Consultation Response from KC, Lead Local Flood Authority
2021/92086 land at, Bradley Villa Farm, Bradley Road, Bradley, Huddersfield, HD2 2JX
Erection of 277 residential dwellings and associated infrastructure and access (amended scheme)
Date Responded: 6th June 2022 Responding Officer: Paul Farndale Responding Ref:

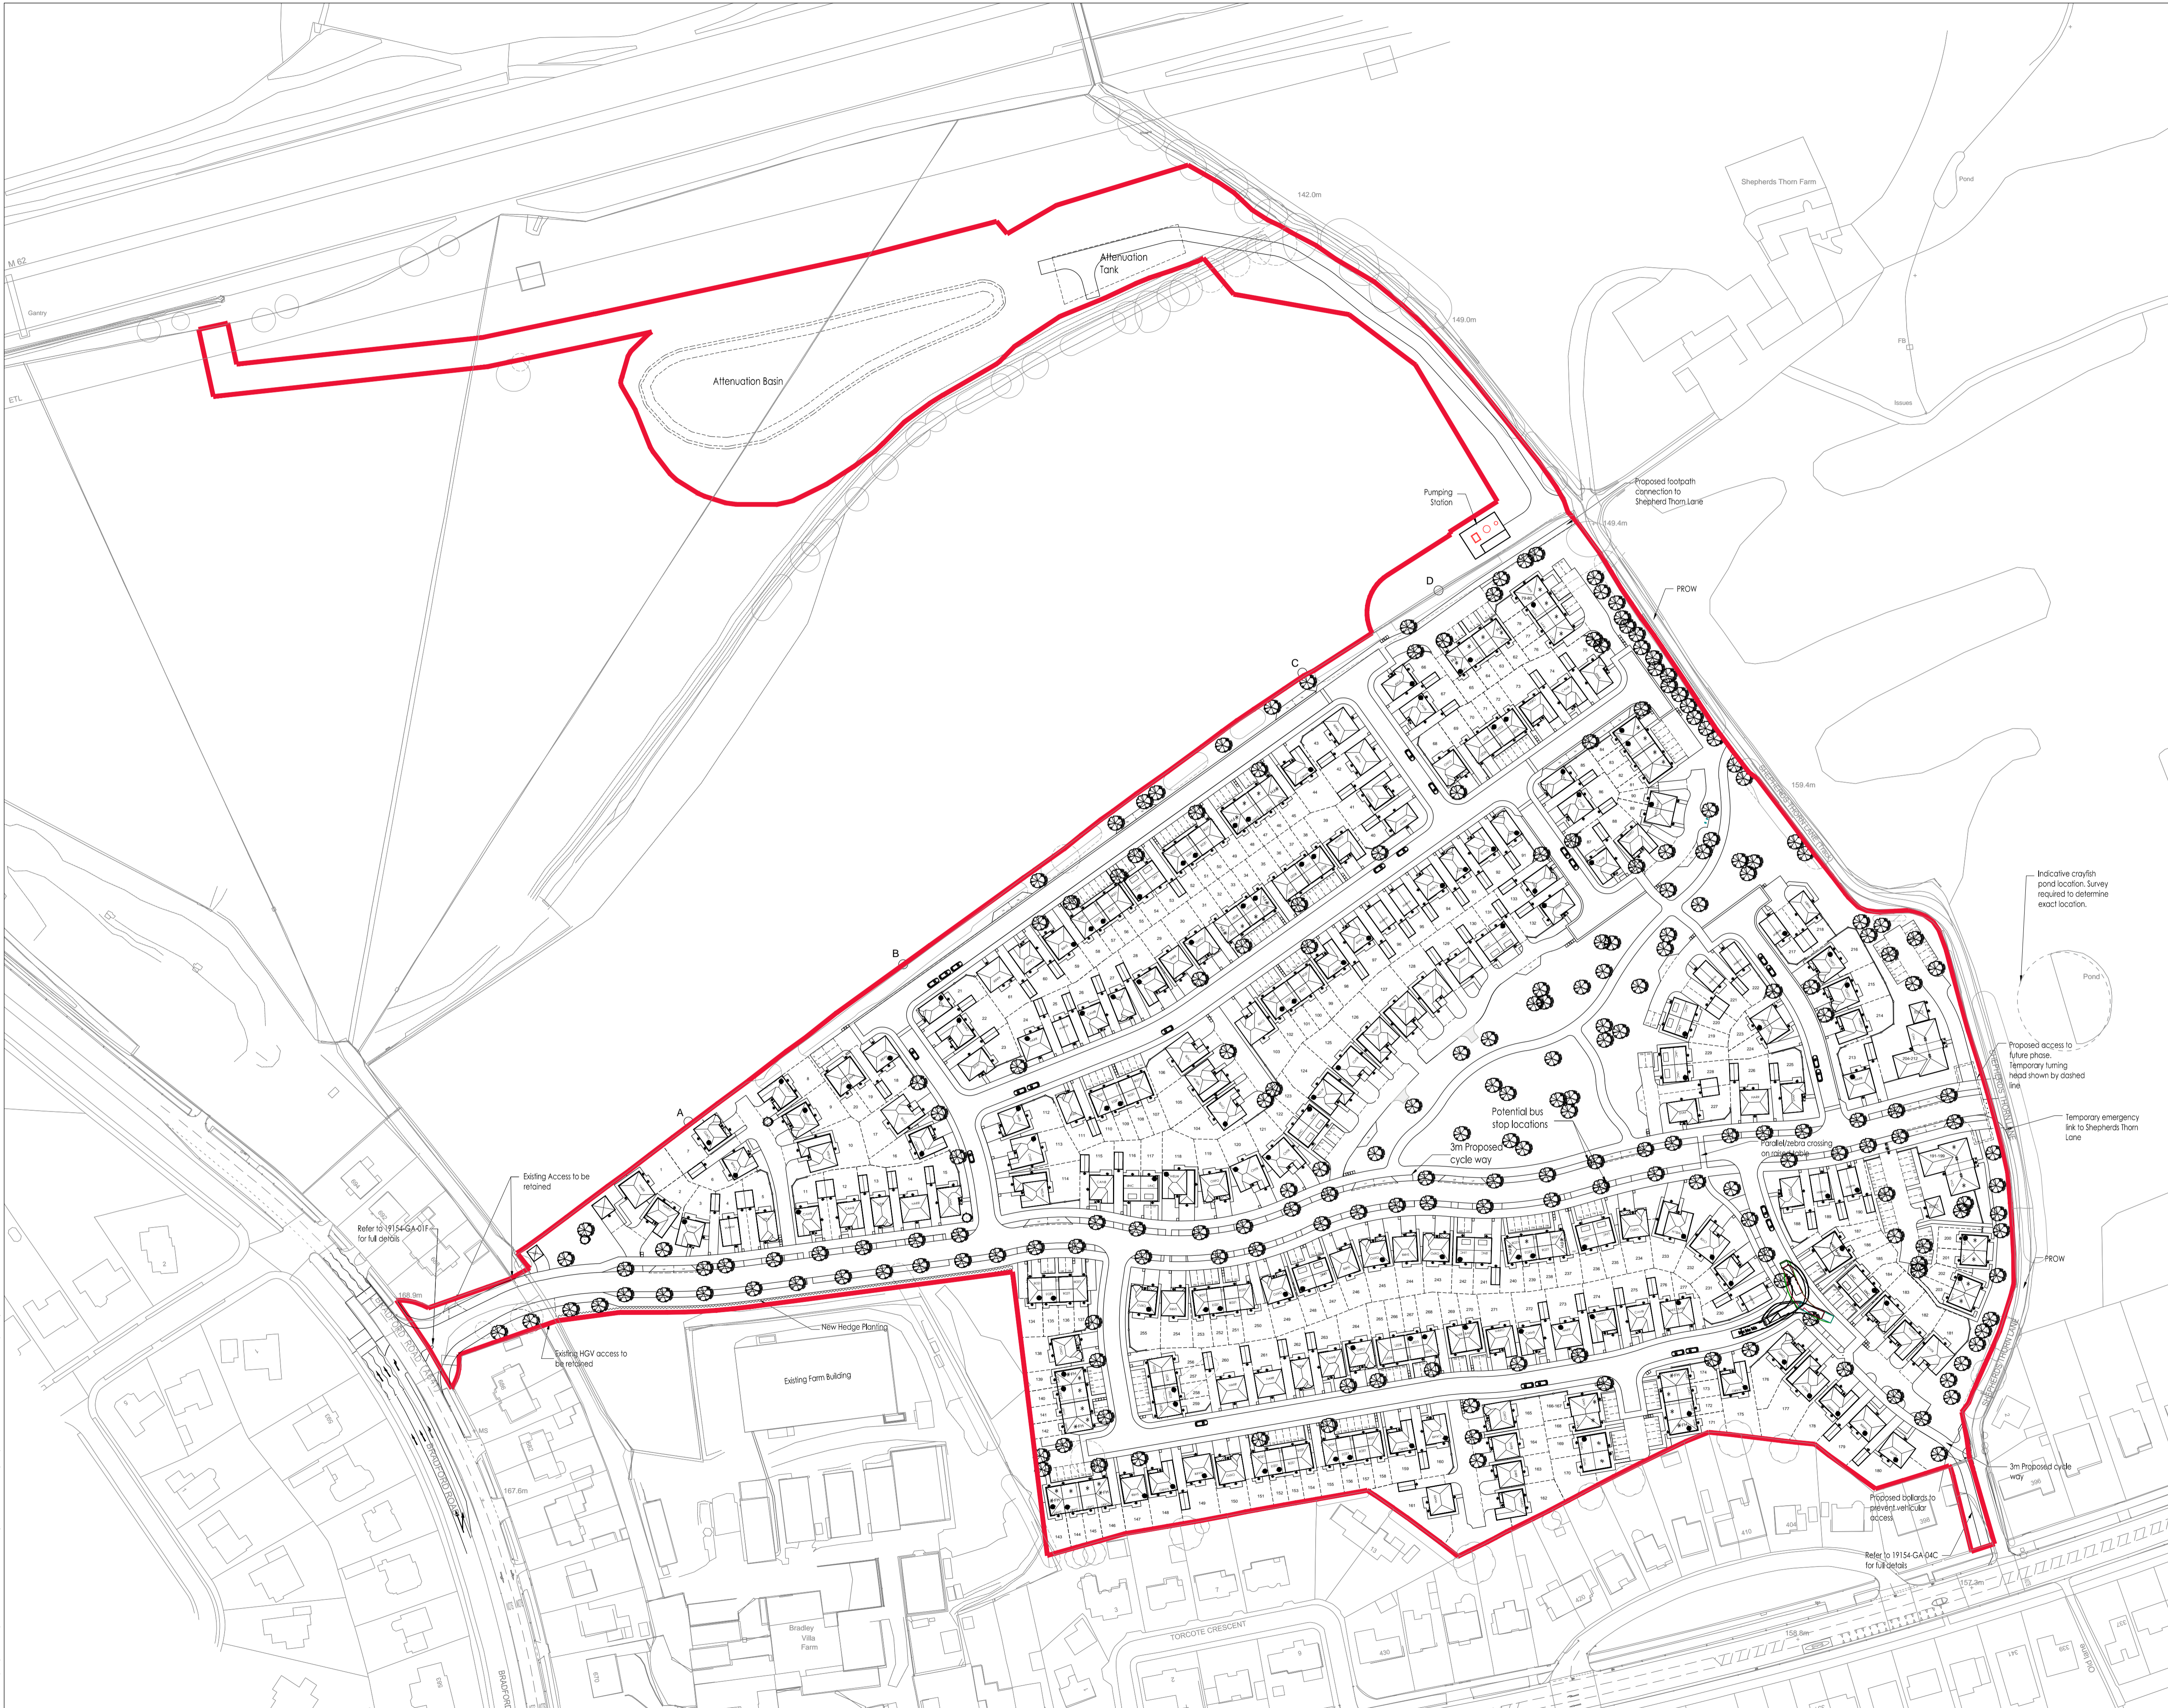
We do not accept a layout that fails to take flood routing as a constraint for design and therefore utilises curtilage, i.e. simply maps the flood routing around the promoted layout and fails to avoid risk. Roads and public open space should be used for flood routing not curtilage as a standard. We suggest a review with the planning officer, LLFA and applicant.
